Recommendation Report for Planning Permission for Works or Extension to a Dwelling

REF NO: FP/239/12/

LOCATION: 59 Crossbush Road
Bognor Regis

PROPOSAL: Demolition of existing single storey garage and the construction of a ground floor single storey rear and side extension (resubmission following FP/140/12/)

JOB NO.	DWG NO.	REVISION	PROJECT	STATUS	PLANNING	ARCHITECTS
CL233	0002	B	59 CROSSBUSH RD FELPHAM, BOGNOR REGIS, WEST SUSSEX PO22 7LY			COPPING LINDSAY ARCHITECTS 14 BETHLEY STREET LONDON SE11 4AJ pete@lindsayarchitects.com tel : 020 3341 9604 fax : 020 7582 9498

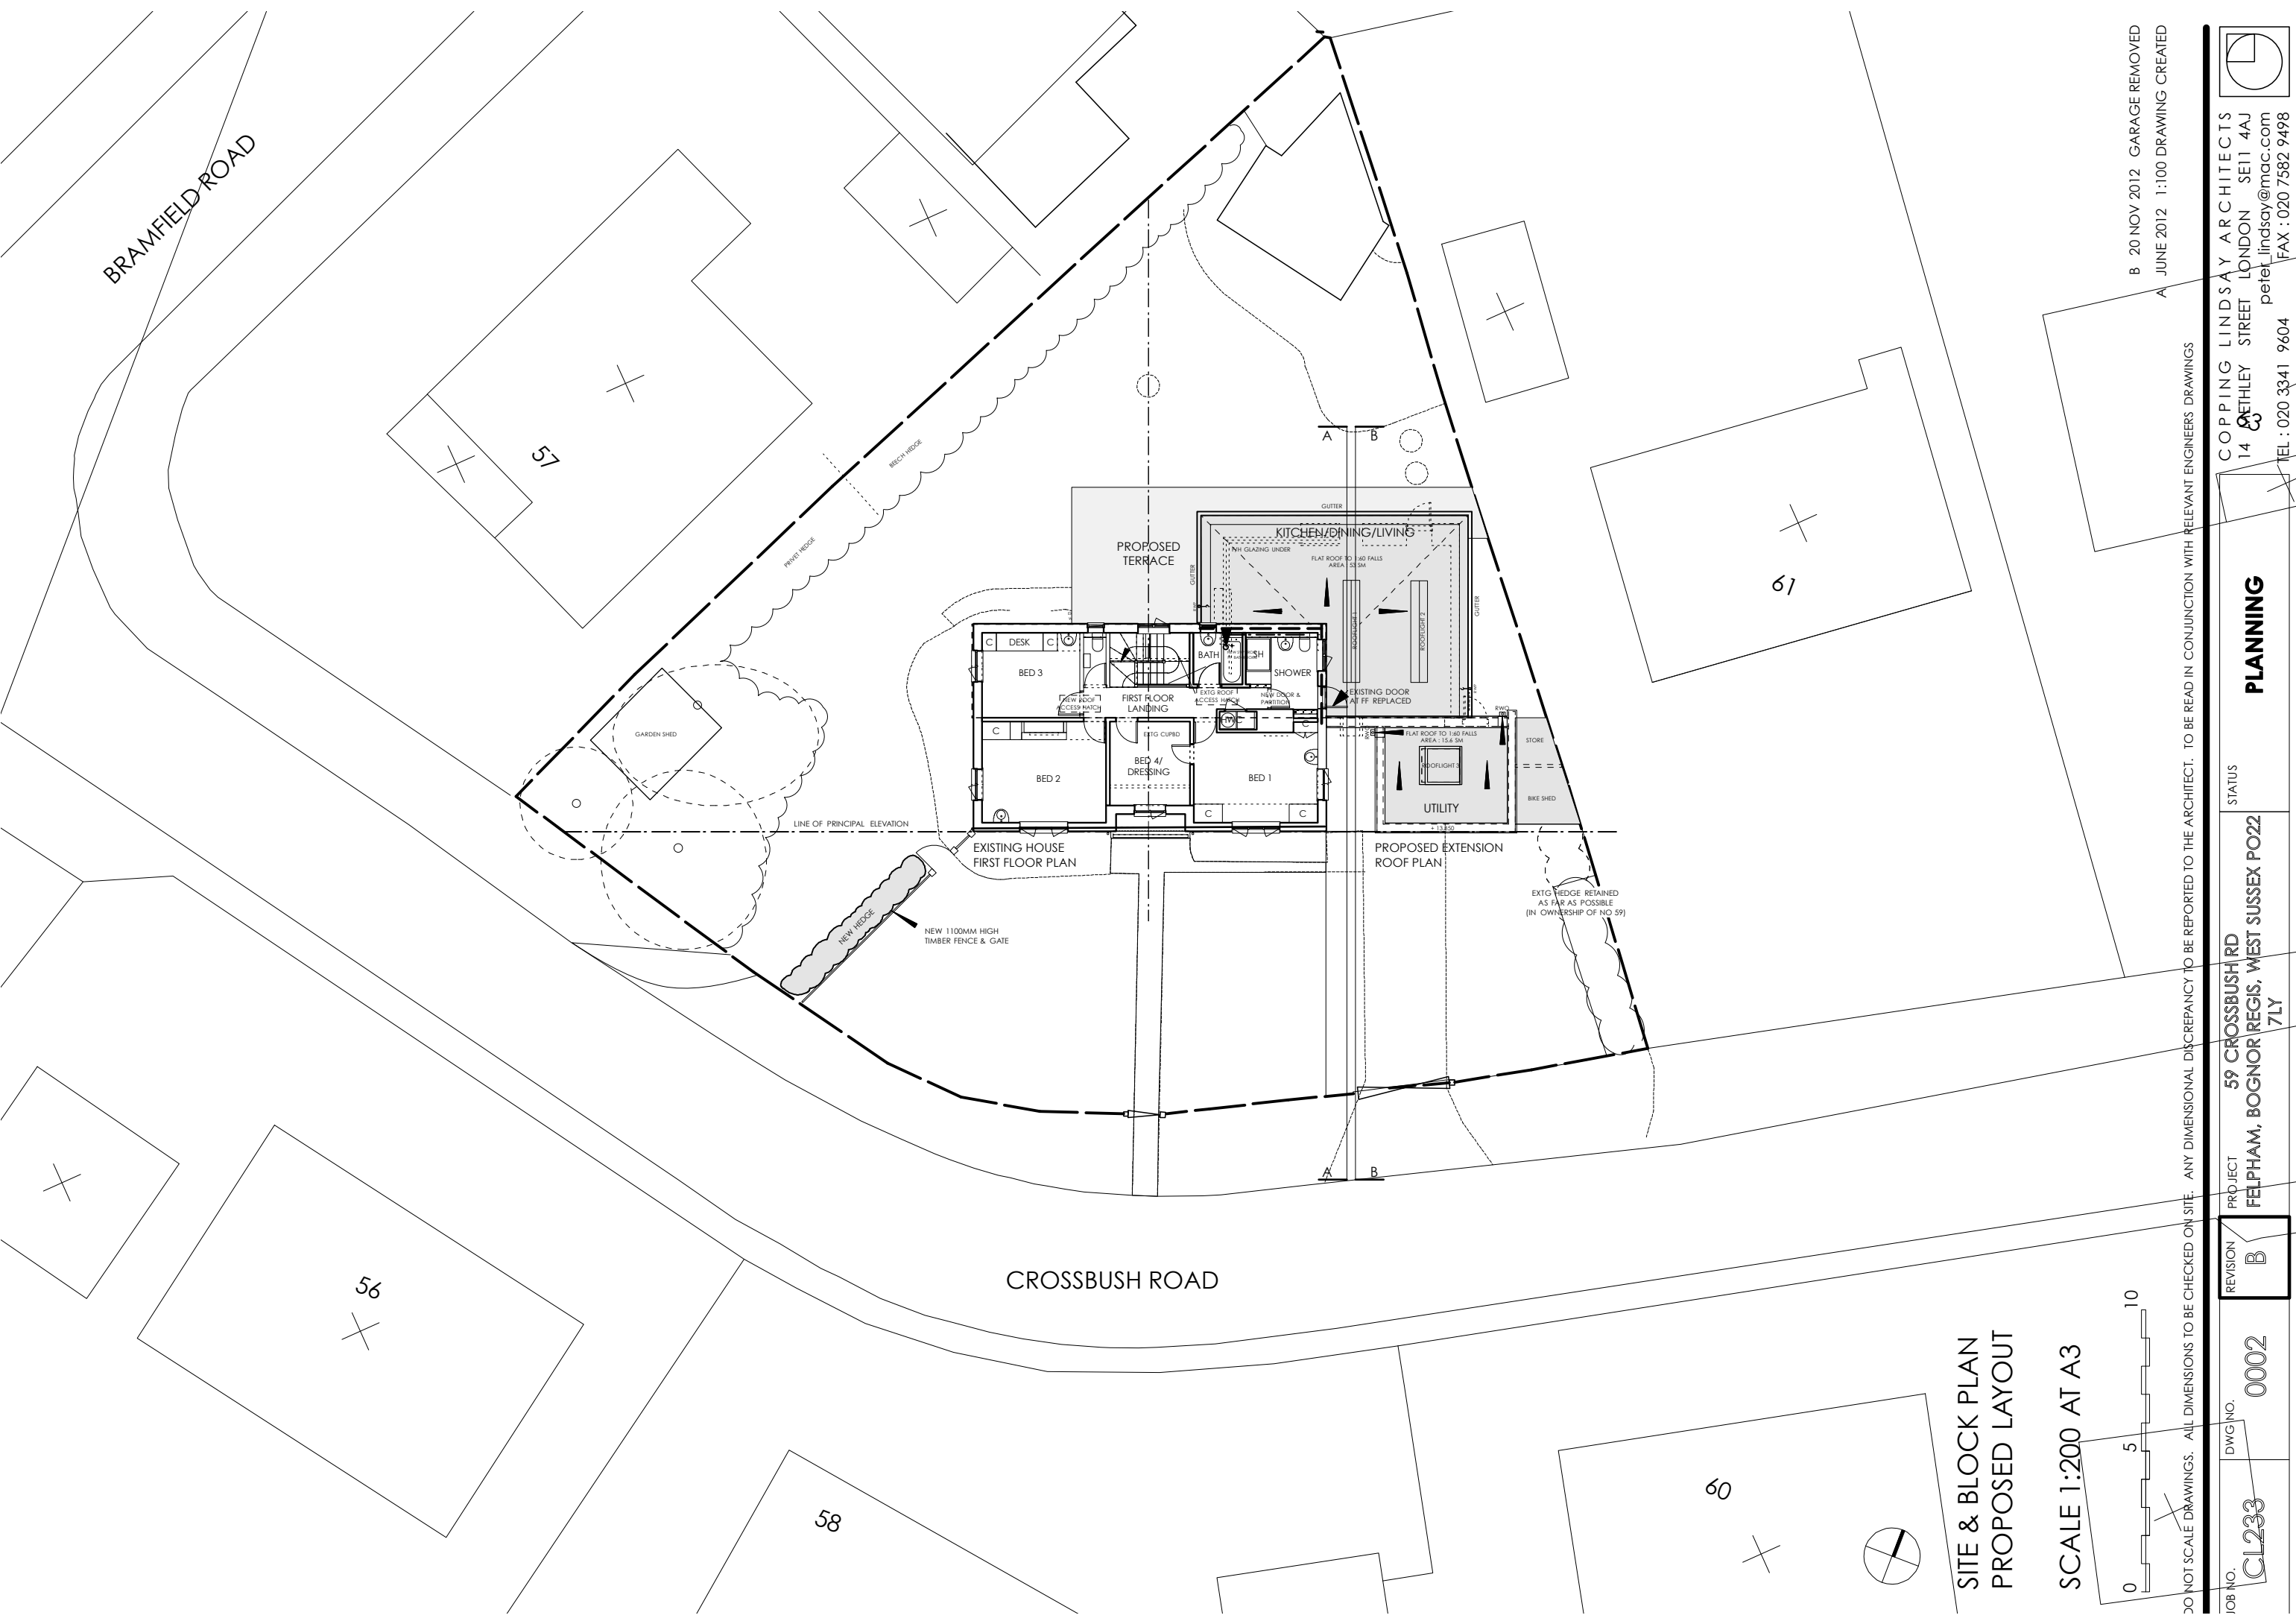
A hardstanding of approximately 56 sq metres is proposed to be finished in either tarmac, gravel or concrete block paving. A condition is recommended to secure sample materials for the new hardstanding.

- 3 No development shall commence unless and until a schedule of materials and finishes to be used for the hardstanding have been submitted to and approved in writing by the Local Planning Authority, and retained as such thereafter.

GROUND FLOOR PLAN
PROPOSED LAYOUT
SCALE 1:100 AT A3

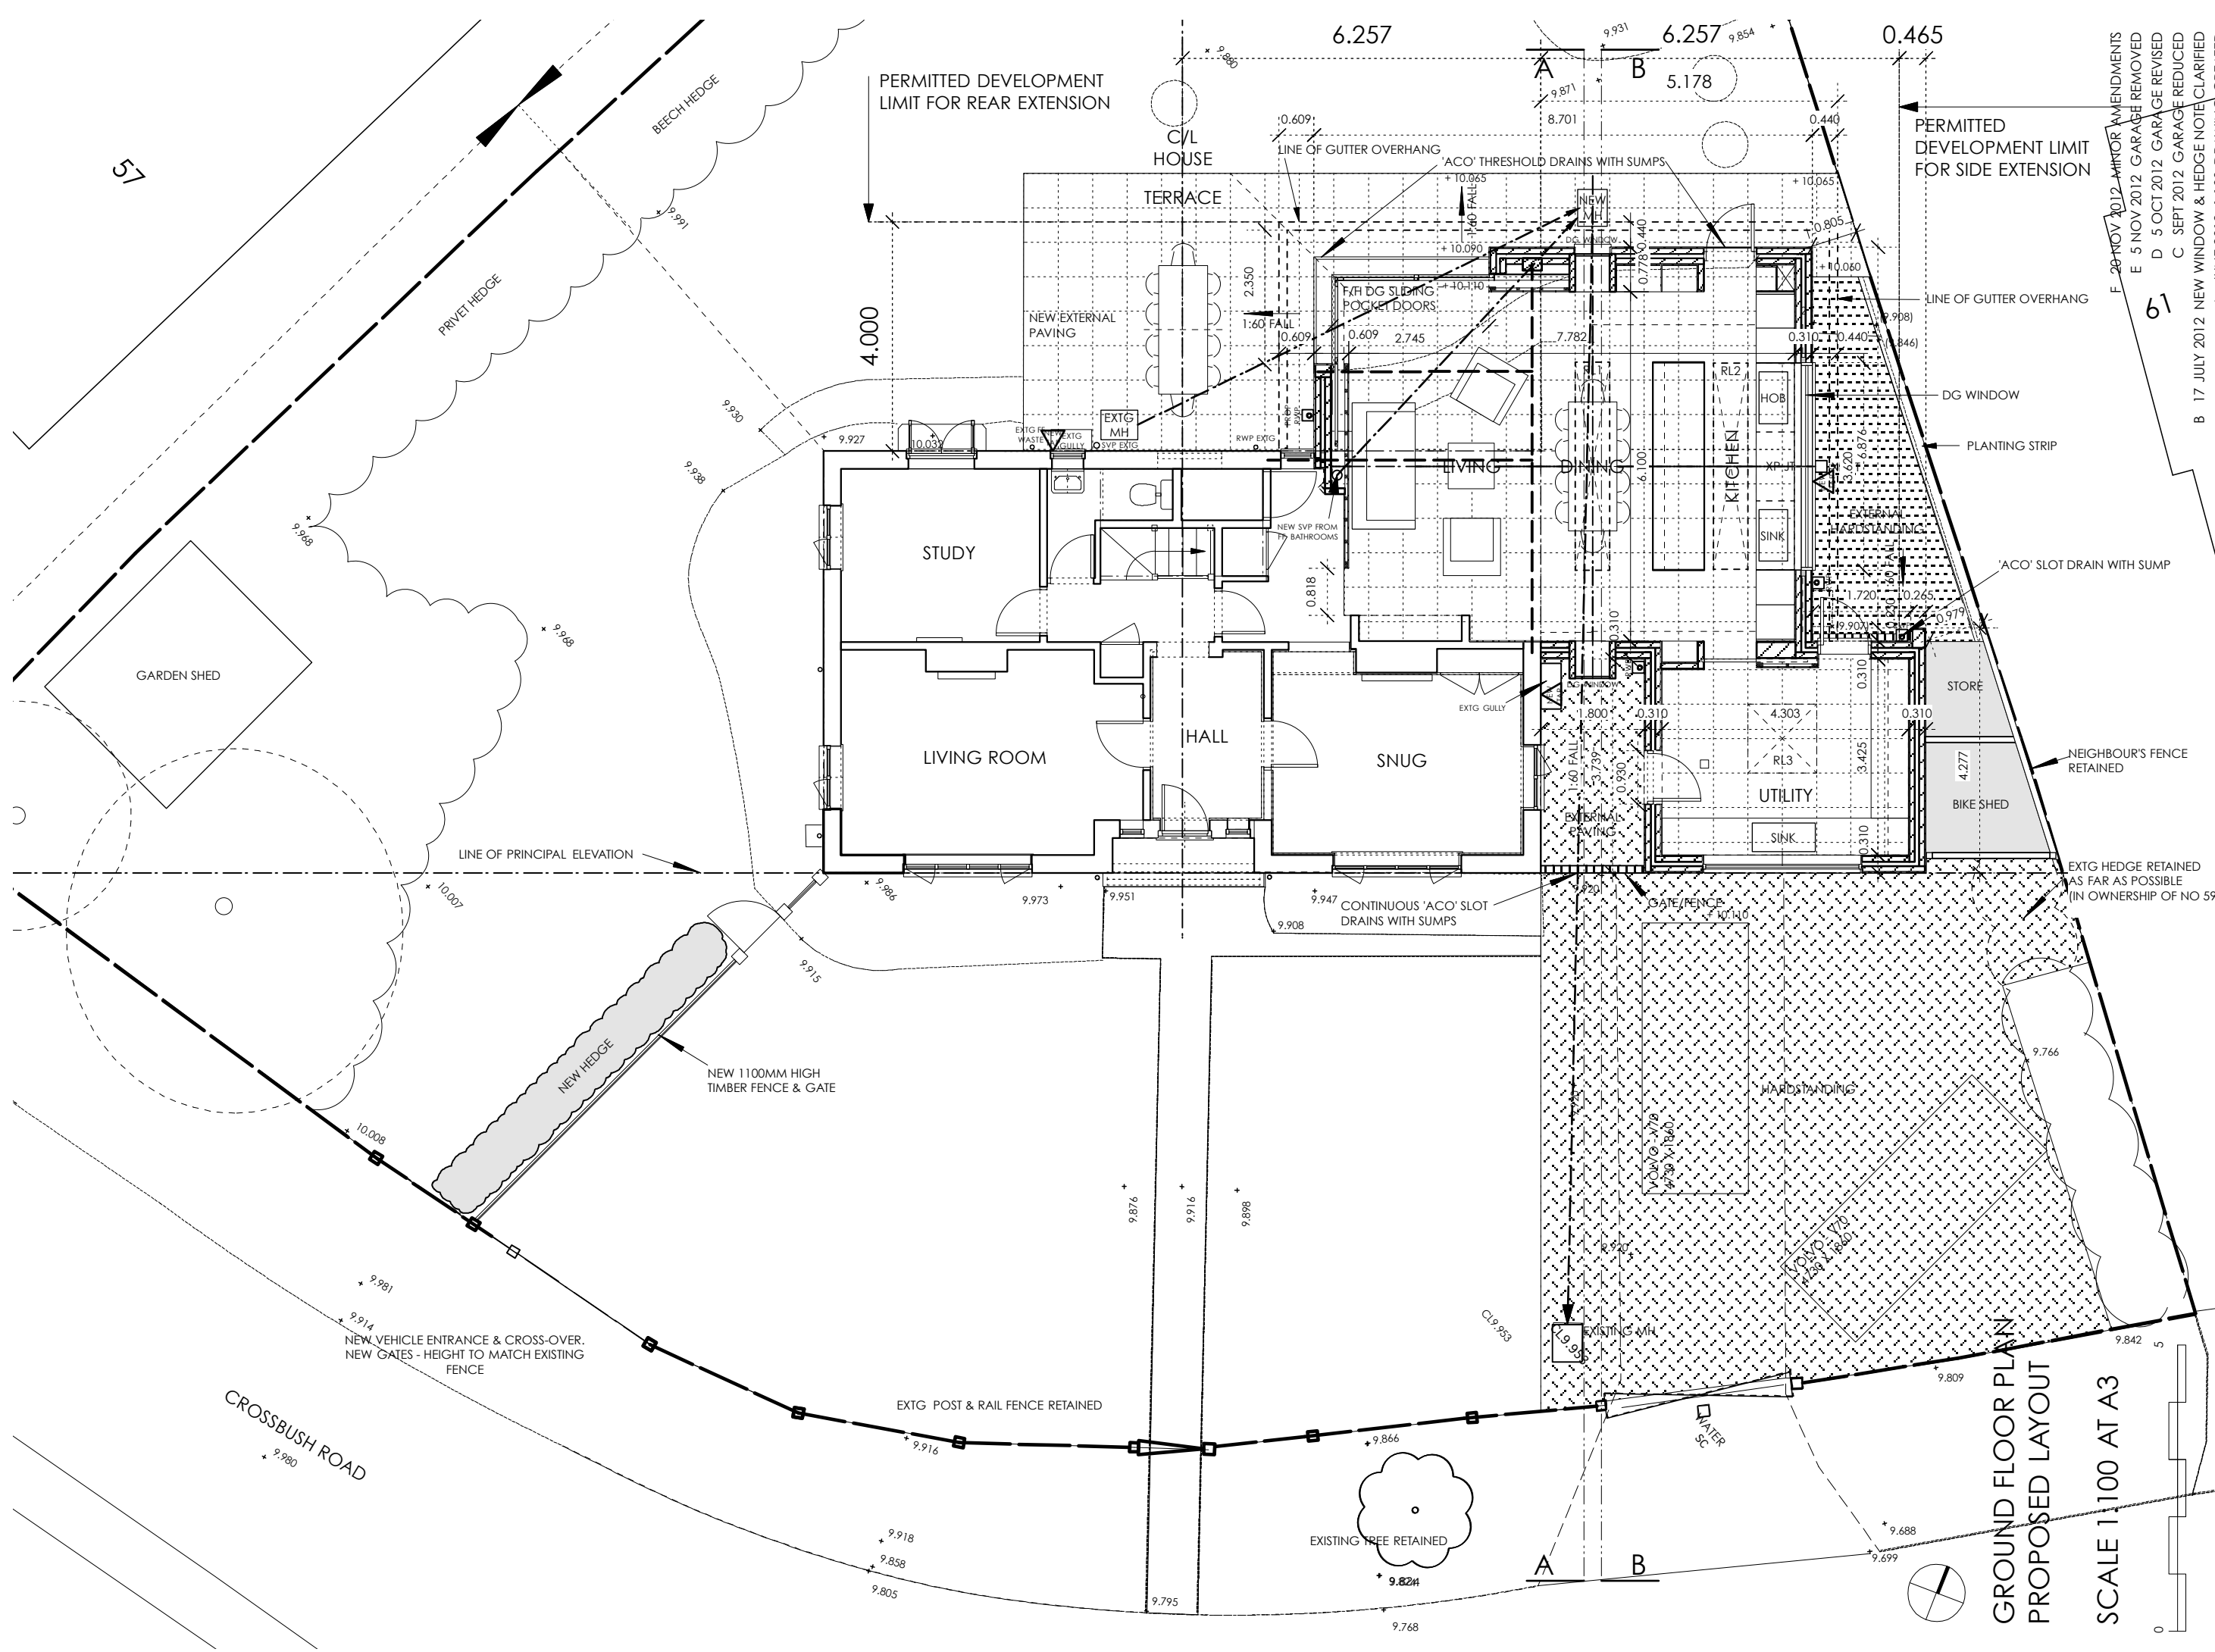
The proposed utility room extension will have a flat roof with parapet wall and the proposed living room/kitchen extension to the side and rear will have a flat roof with projecting eaves. The extensions will be faced in white painted render with concrete parapet copings. They will be sited on the east and north elevation of the dwelling. The proposed extensions will replace an existing flat roof side garage and are visually subservient to the host dwelling.

The side extensions will be sited within 800mm of the common boundary at the narrowest point at a maximum height of 3.3 metres. The front garage extension is omitted altogether. The proposal is considered to have a less overbearing impact on the amenities of this property and will not harm the privacy, outlook or daylight to the neighbouring property.
